**KIRKLEES METROPOLITAN COUNCIL  
INVESTMENT & REGENERATION SERVICE**

Reference No:	<b>2025/44/92126/W</b>
Site Address:	adj, 7, East Street, Jackson Bridge, Holmfirth, HD9 1HY
Description:	Discharge of details reserved by conditions 6 (bin storage), 8 (materials), 10 (bat box), 11 (electric vehicle recharging) on previous permission 2020/91456 for erection of detached dwelling
Recommending Officer:	Emma Thompson

**DECISION – Discharge of Conditions - Refused**

**Date: 02-Oct-2025**

Drawing Number\_  
 24\_809 121

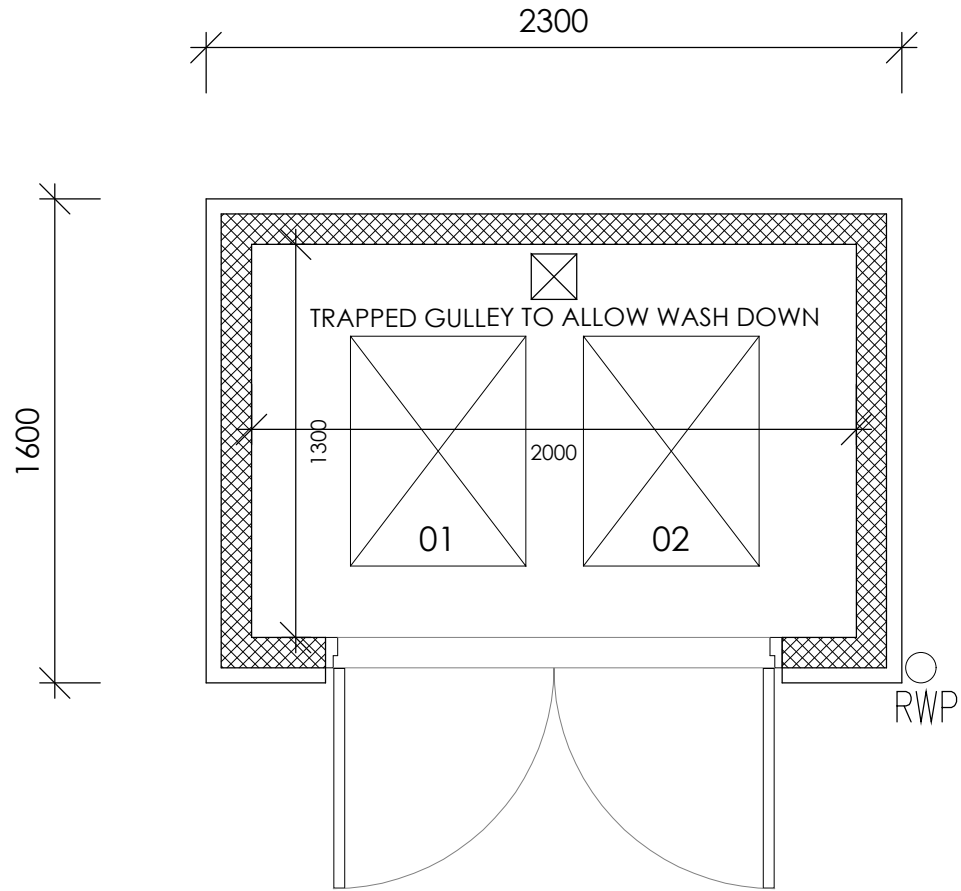
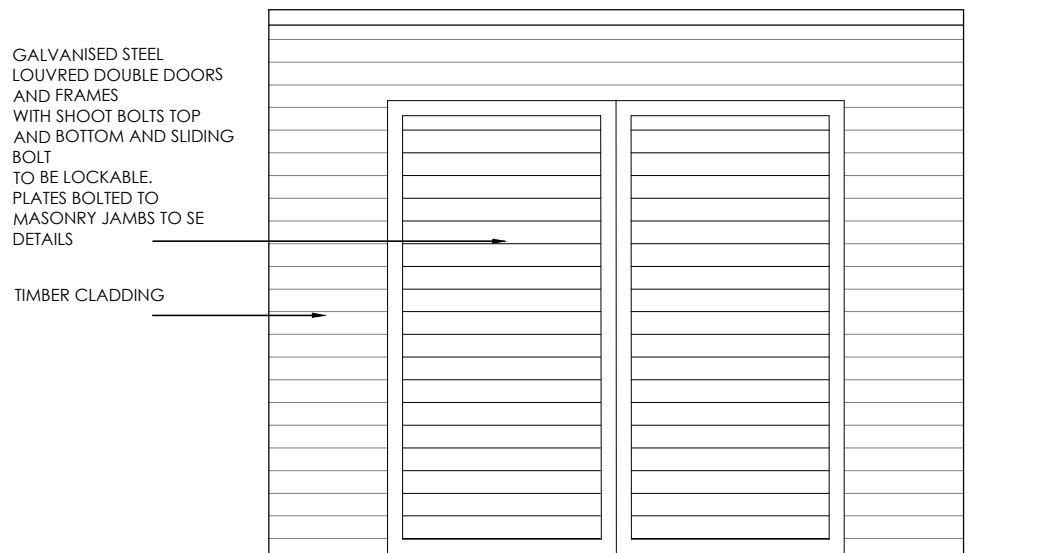
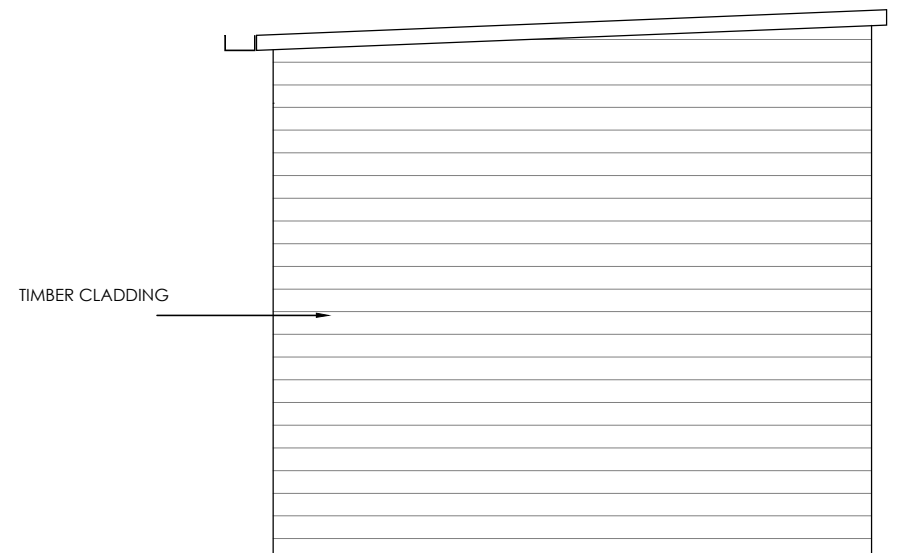
Site plan reference 24\_809 120 has been submitted showing the bin storage and presentation points and bin store details on 24\_809 121. KC Waste Strategy have been consulted on the details and full comments are available on the Kirklees Website:

Concerns are raised regarding the size of the storage unit as well as the presentation point. The store is shown to the front of the integral garage blocking access to this space.

The bin store is not considered large enough and needs to be increased to hold 3 wheeled bins, given that a third bin will be required for garden waste or for the introduction of the new Simpler Recycling legislation.

The details provided are not adequate for the discharge of Condition 6. A new application will be required.

Site plan reference 24\_809 120 has been submitted showing the bin storage and presentation points. The bin store details are contained within plan reference 24\_809 121. The details are not acceptable and as such Condition 6 cannot be discharged. A new application addressing the concerns outlined should be submitted.
